Ecology response

Subject: RE: P/80/20/DOC

Thank you for consulting us regarding the application to discharge condition 11, we have the following comments:

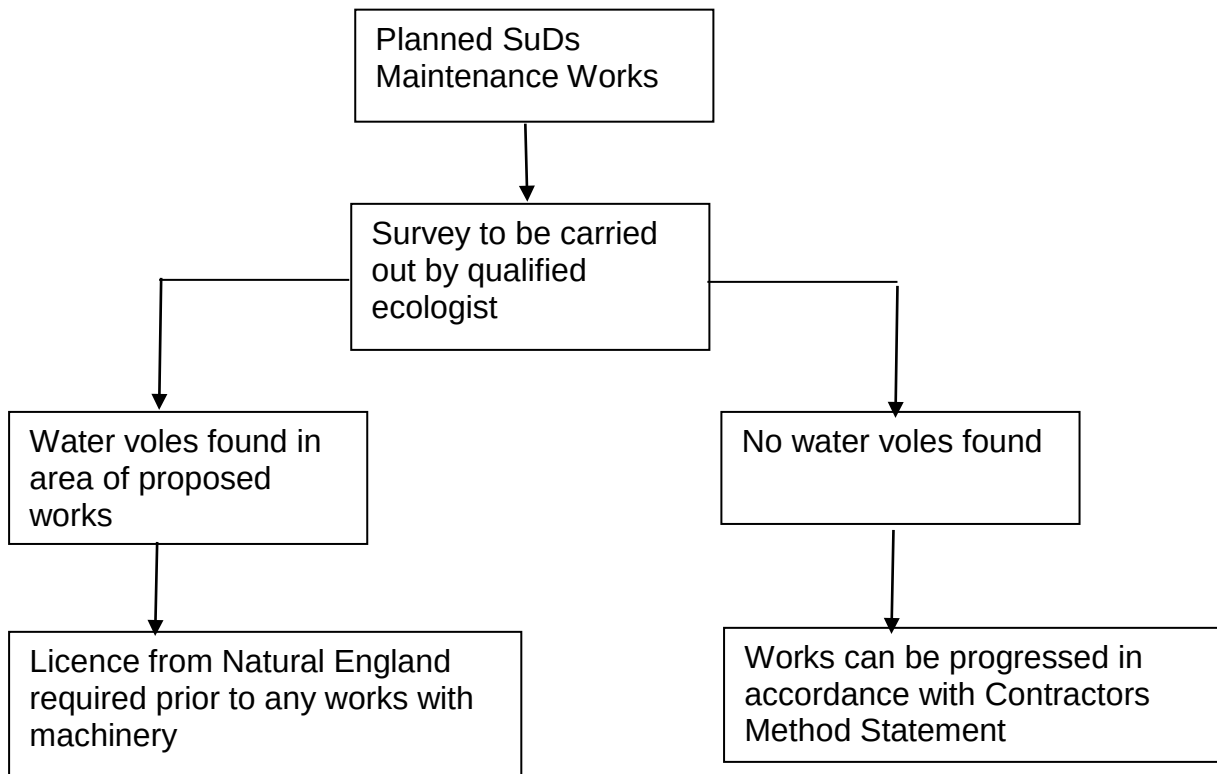
1. Please can you add details of maintenance of the bypass doors for the hydrobrakes, i.e. frequency of operation tests and oiling.
2. Please expand sediment removal for attenuation basins, bioretention areas and swales to include all areas, not just inlets outlets and forebay.
3. Within the attenuation basin maintenance please include details of requirements for maintenance/ replacement of liner, low flow channel, gabion mattress. This should include details of expected design lives.

4. Please include a plan which clearly shows the areas of watercourse that the development will have riparian responsibility for.
5. Please detail the requirements for maintenance of the elements of the engineered channel within the ditch maintenance section. It would be beneficial to refer to design drawings here too in case elements have to be reconstructed during the development lifetime.
